August 7, 2017

**Subject: Onejoy Place  
Response to Peer Review Comments**

Our office received peer review comments for the above referenced project from Thomas Errico, P.E. at T.Y. Lin International, dated July 7, 2017 and Lauren Swett, P.E. and Craig Sweet, EIT at Woodward & Curran, dated July 6, 2017. We have reviewed the comments and have prepared the responses presented below. For clarity, each comment is repeated in italics, followed by our response.

SHEET **C-6.0**

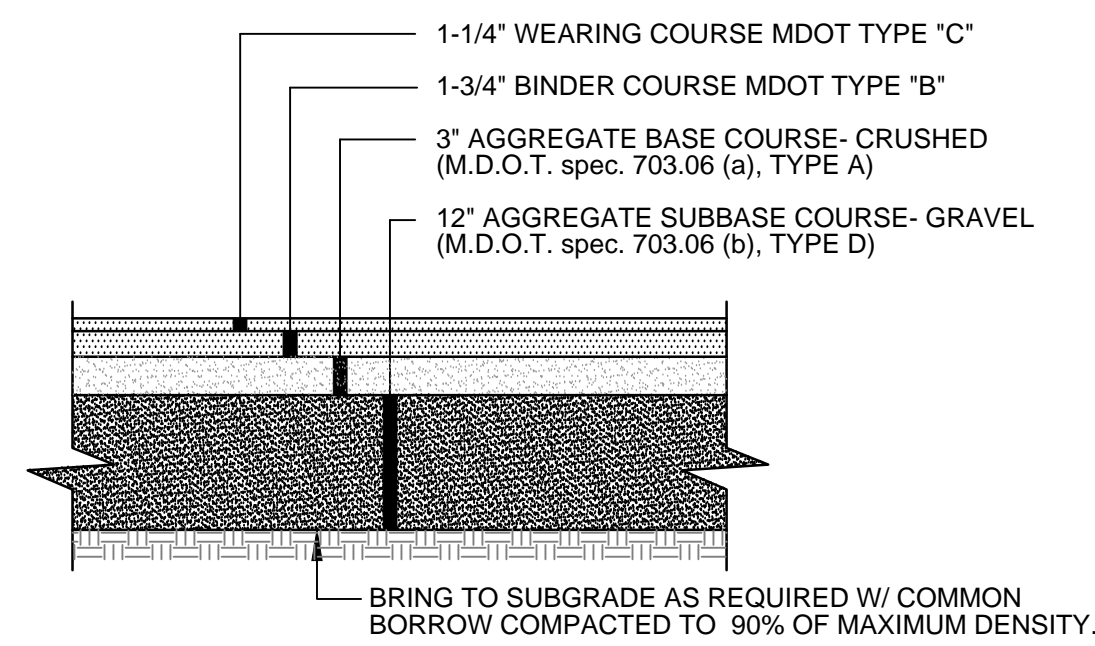
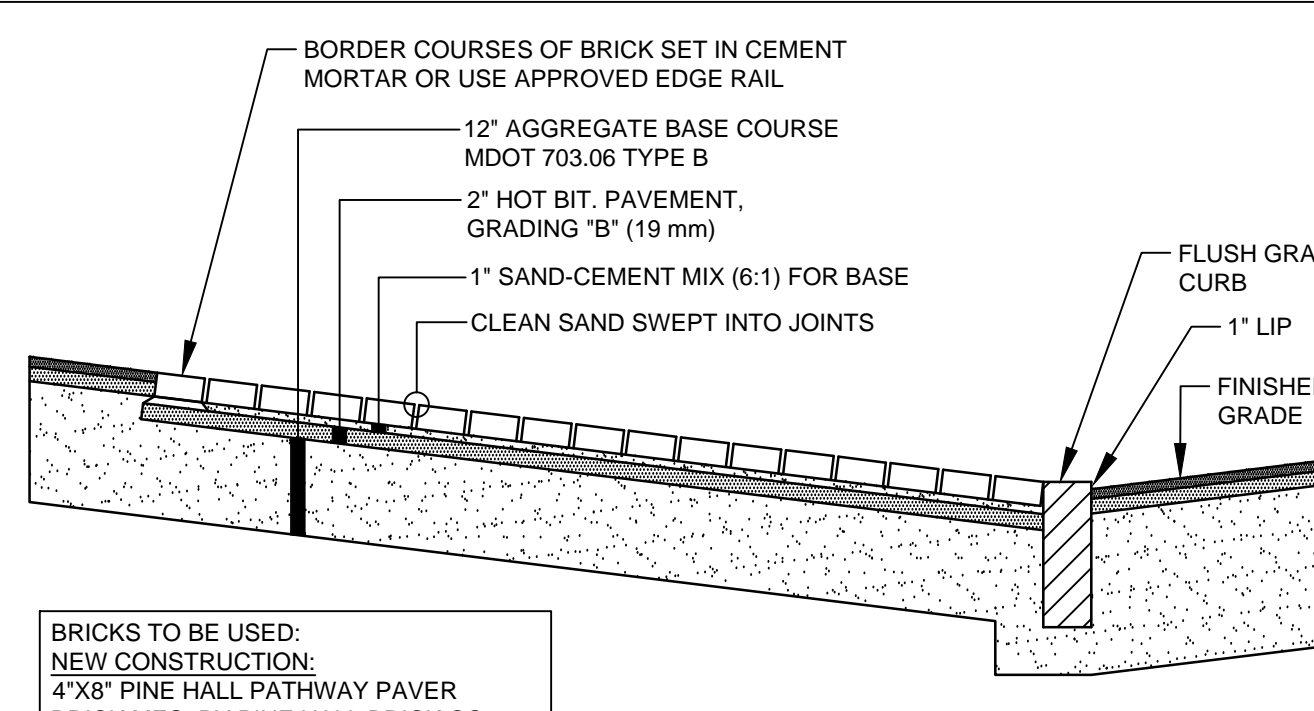
*Comment 4: All work within the City Right-of-Way is required to comply with City of Portland Technical Standards. Brick sidewalk and pavement details for work within the right of way should be in compliance with the Technical Standards.*

Response: The brick sidewalk detail has been modified to comply with the City of Portland Technical Standards, and a detail for pavement repair within the City Right-of-Way is provided on Detail Sheet C-6.0.

TYPICAL TRENCH DETAIL
NOT TO SCALE

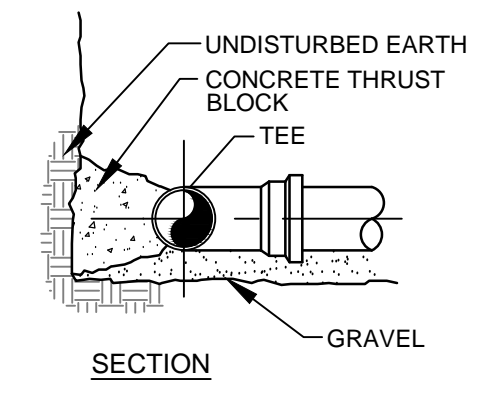
*Comment 5: The pipe burial detail notes that minimum cover is 1 foot. It was noted that in some areas cover over pipe will be less than 3'. Insulation should be provided in areas with minimal cover to prevent freezing.*

Response: Insulation notes have been added to the "Typical Trench Detail" on Sheet C-6.1.
